A/121/15/PL – HERONS FARM, DAPPERS LANE, ANGMERING

As the owners and occupiers of the adjoining property, we should like to register the following objections and concerns regarding the above Planning Application A/121/15/PL for the demolition of existing structures and the construction of two cottages, stabling and a sand school. We have made our neighbours aware of these concerns.

Job Title
SITE LAYOUT

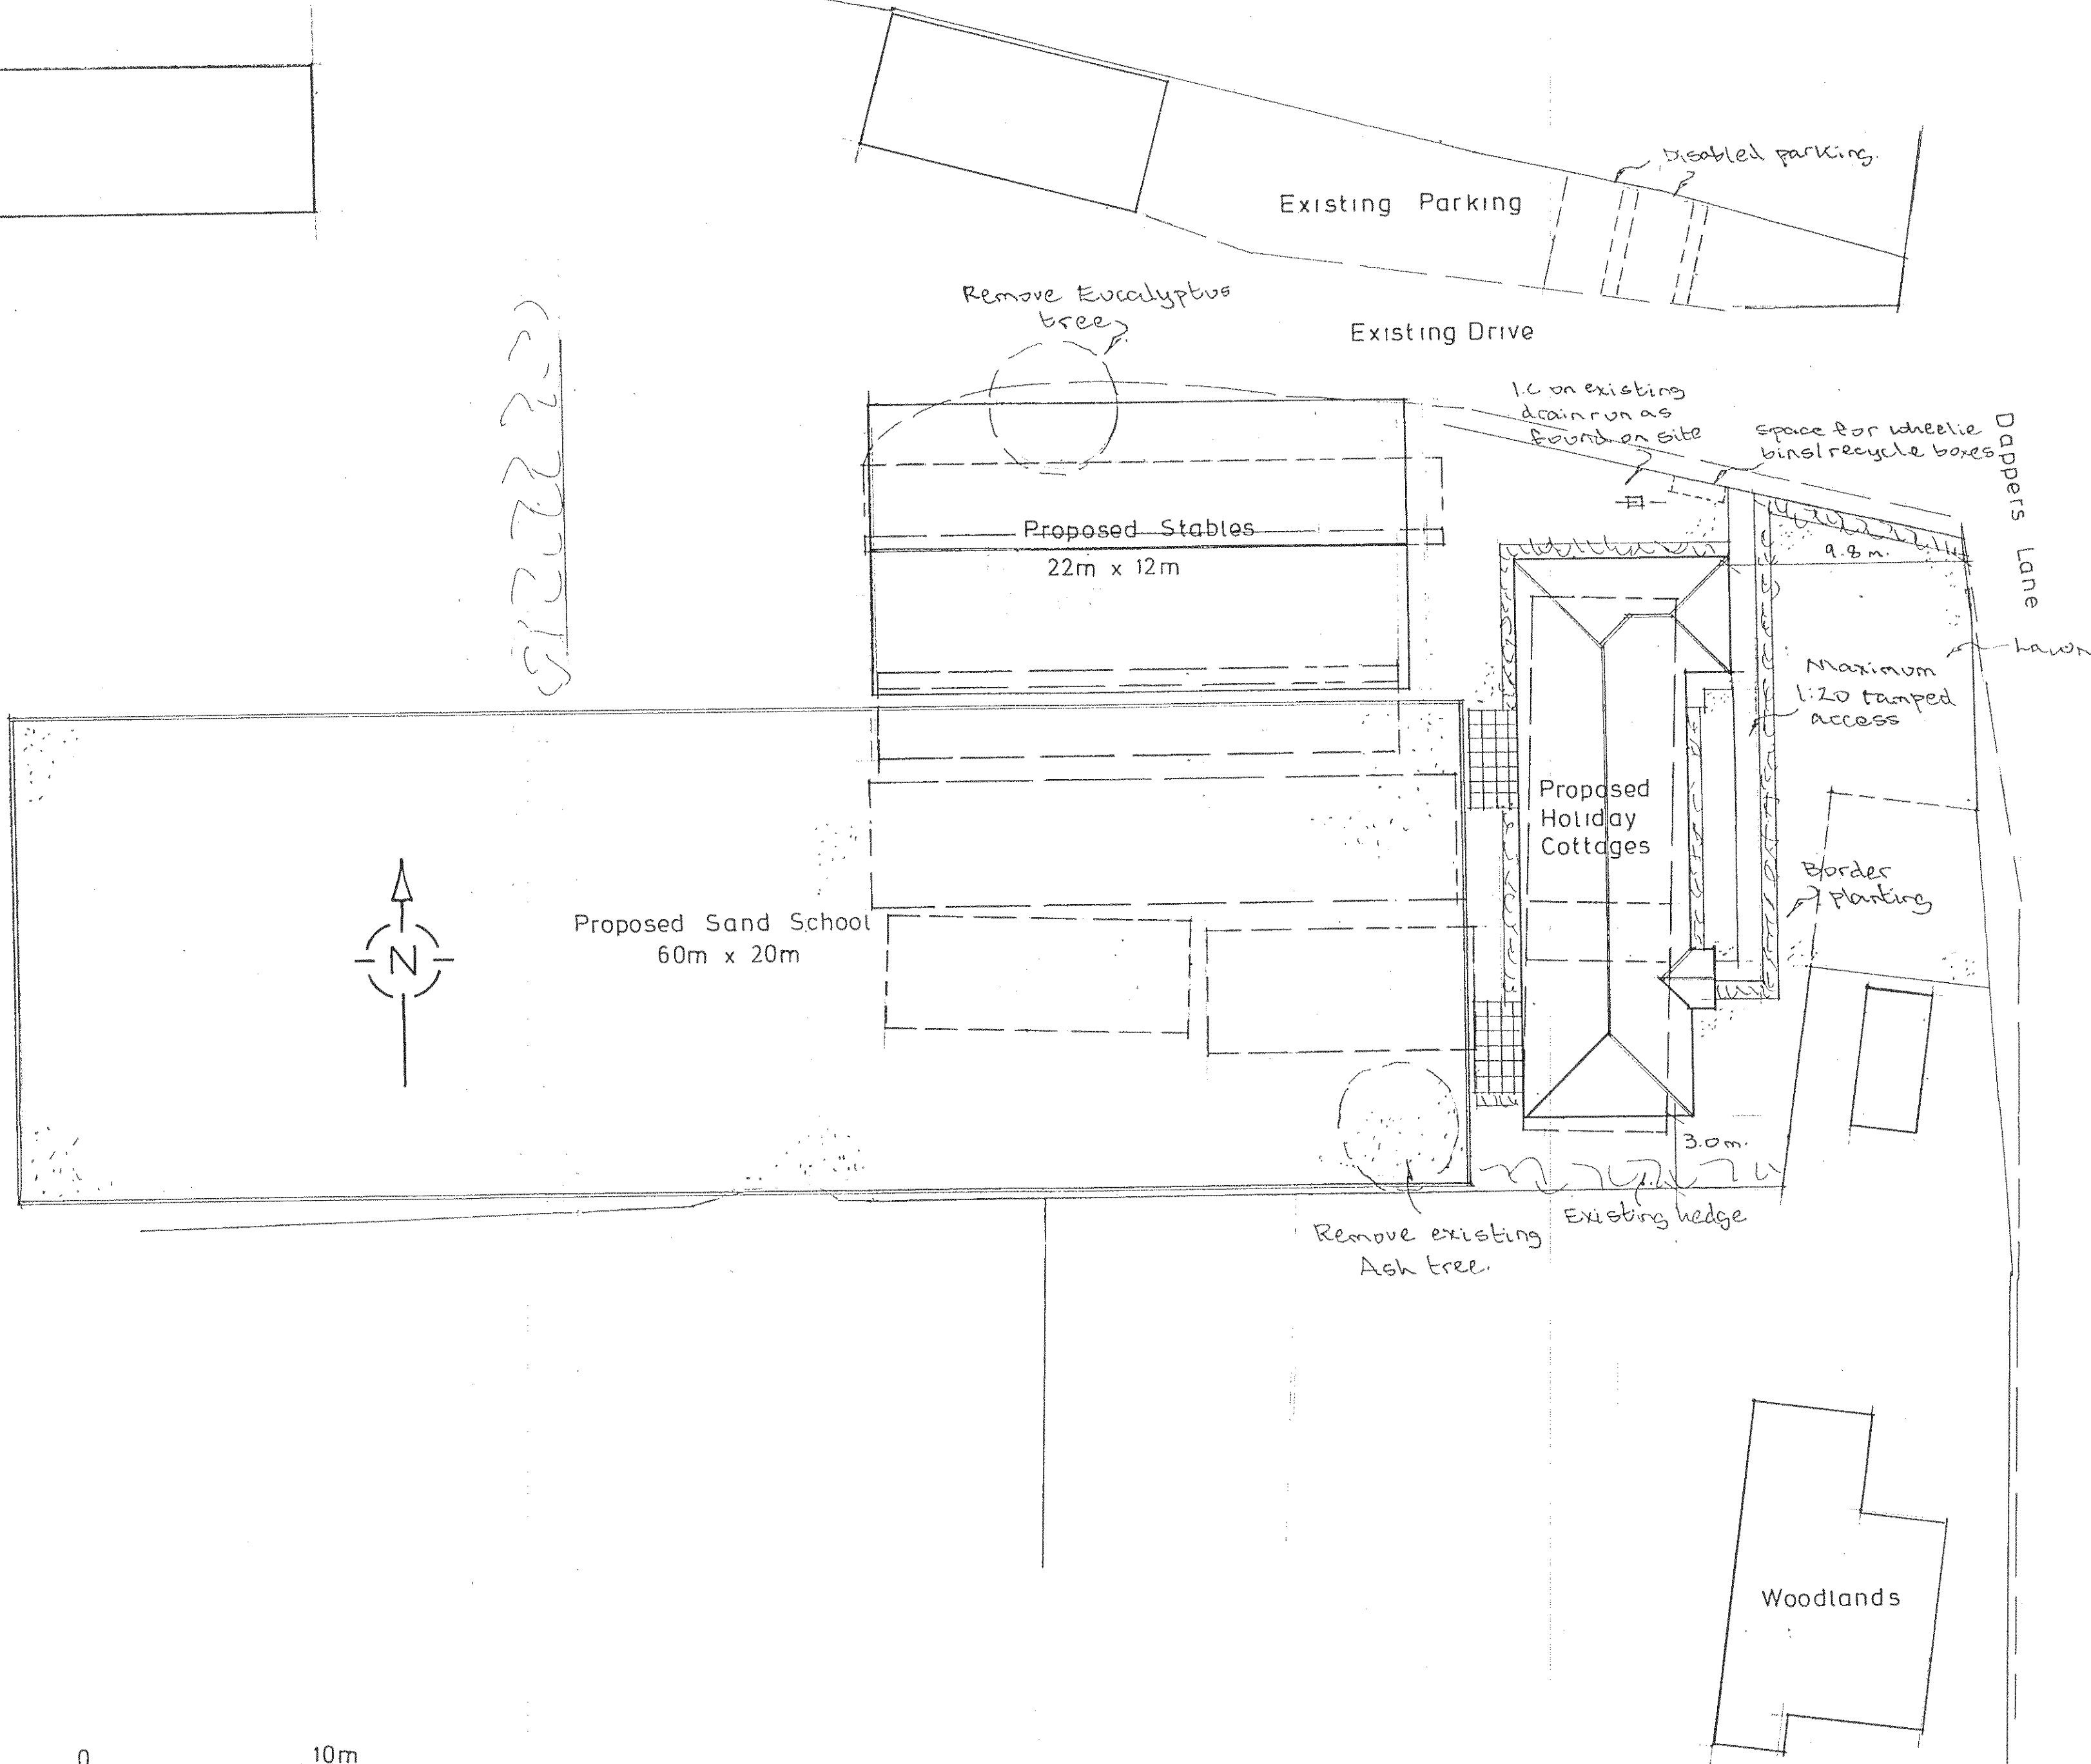
In respect of the boundary to the south and east of the proposed cottages, the plan shows "existing hedges". There is no existing hedge – the boundary is defined by fencing, currently in a poor state of repair and thickly covered by ivy and other vegetation. During our discussions with our neighbours (the applicant) they have indicated a willingness, through a combination of replacement fencing and lowering the foundation level of the cottages, to prevent our property from being overlooked. Whilst we appreciate this, in order to completely preserve our privacy it would result in the height of a fence or wall being very overpowering and intrusive in itself, and would be totally out of keeping with the rest of our garden and, indeed, the rural nature of this area. Additionally, it would not address the issue of noise disturbance from, potentially, a continuous stream of different people (including children) enjoying short stay holidays.

Proposed Block Plan

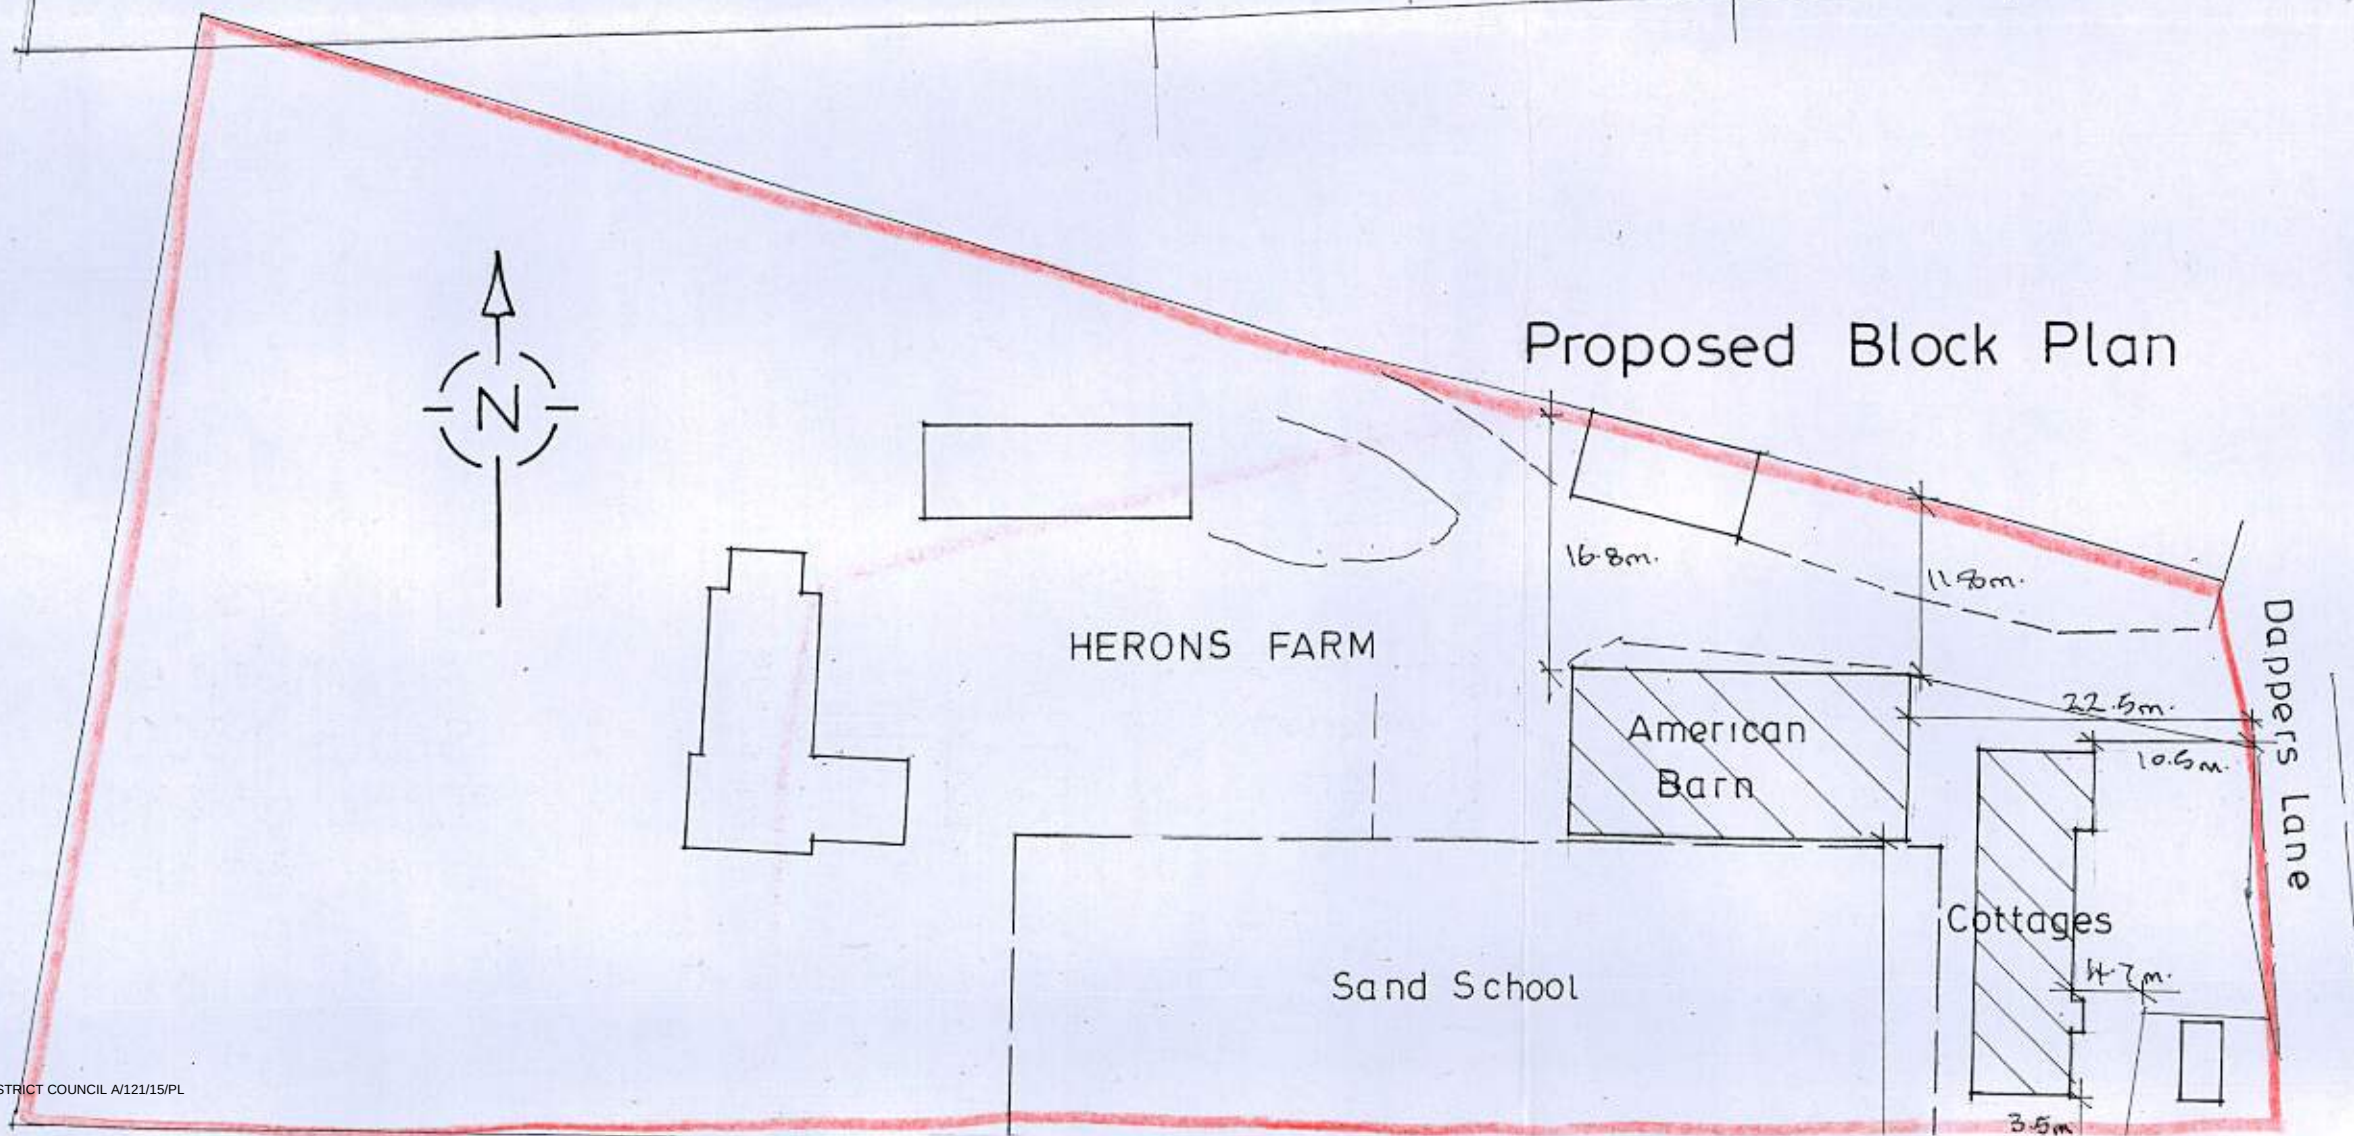
The application is to build the two cottages just 3.5 metres from the northern boundary of our home and garden in a position which is at the nearest point to our house. Although of single storey construction, the fact that the cottages would be built on land which is significantly elevated will mean that our property will be overlooked from the windows on the West, East and the South sides. This, together with the inevitability of noise generated by holiday occupiers of the cottages (potentially throughout the year) and from the sand school, would result in loss of our privacy and disrupt the peace and tranquillity of our home and garden. We understand there is also an intention to create a garden for each of the properties. The north cottage garden would be in front of that building and the one for the south cottage would be situated between that building and our boundary thereby further increasing the level of disturbance.

Heron's Farm is situated within a large parcel of land, giving scope for the cottages to be constructed much further to the West. The proposed development is sited at the furthest point to the East from the applicants' property but at the closest point to our own, thereby enabling them to protect their own privacy at the expense and to the detriment of the privacy and quiet currently enjoyed by us. Moving the location of the cottages to the West would also mean that they would be sited further from Dappers Lane and, contrary to what is stated on the application form, the currently proposed location will render them visible from the public highway.
